Your Ref: BR/294/21/PL

Our Ref: LM/ARU/22/05A

Date 18th January 2022

RE: 2-10 The Hatters Inn Queensway Bognor Regis PO21 1QT

Drawing Title:
PROPOSED BASEMENT, GROUND, 1ST FLOORS

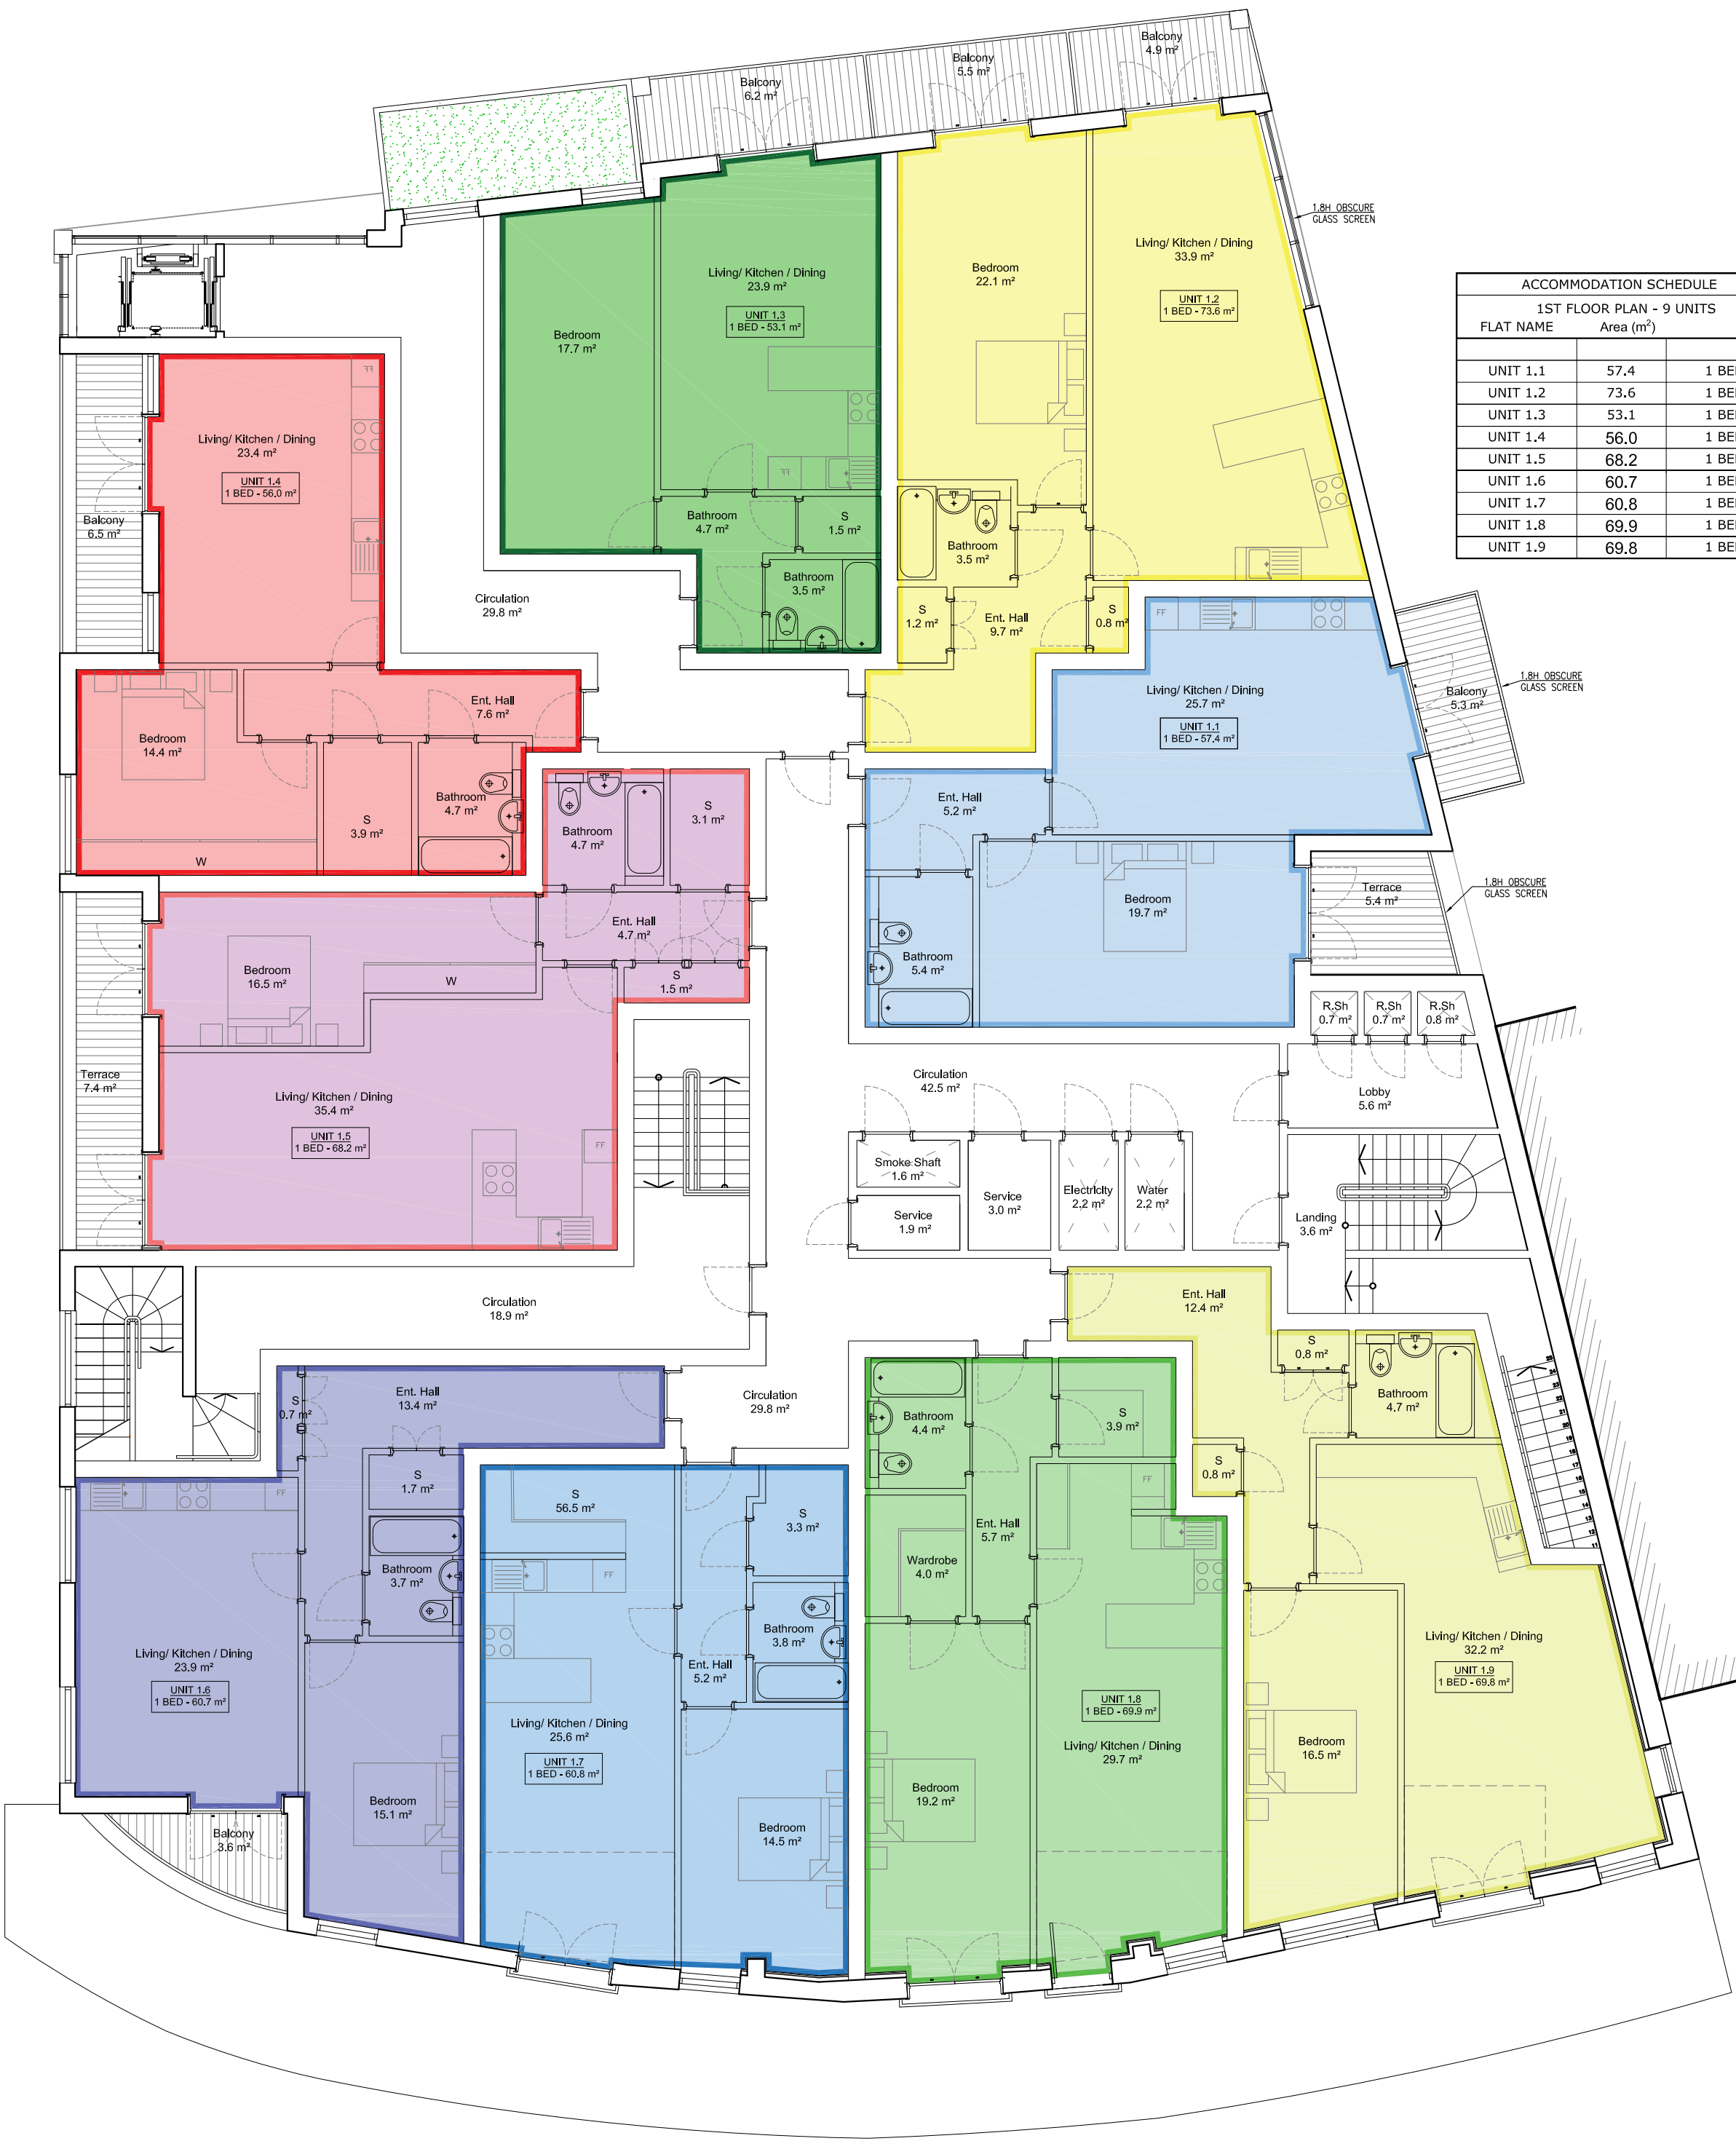
I have some concerns over this development as there is no provision for on-site parking and the addition of 43 homes with their associated cars may have a negative effect on the surrounding local community as new residents compete for car parking spaces within the local area.

I also note that on the ground floor is a public house The Hatters Inn which has the potential to unduly affect the amenity of the proposed residential element above by causing disturbance late into the night 7 days a week all year round.

With regards to the cycle store - research by the 'Design against Crime Centre' suggests that cyclists should be encouraged to lock both wheels and the crossbar to a stand rather than just the crossbar and therefore a design of cycle stand that enables this method of locking to be used is recommended. Minimum requirements for such equipment: • Galvanised steel bar construction (minimum thickness 3mm), filled with concrete; • Minimum foundation depth of 300mm with welded 'anchor bar'. Ideally the cycle store should hold no more than 30 cycles as this will reduce the payoff for a would-be offender.
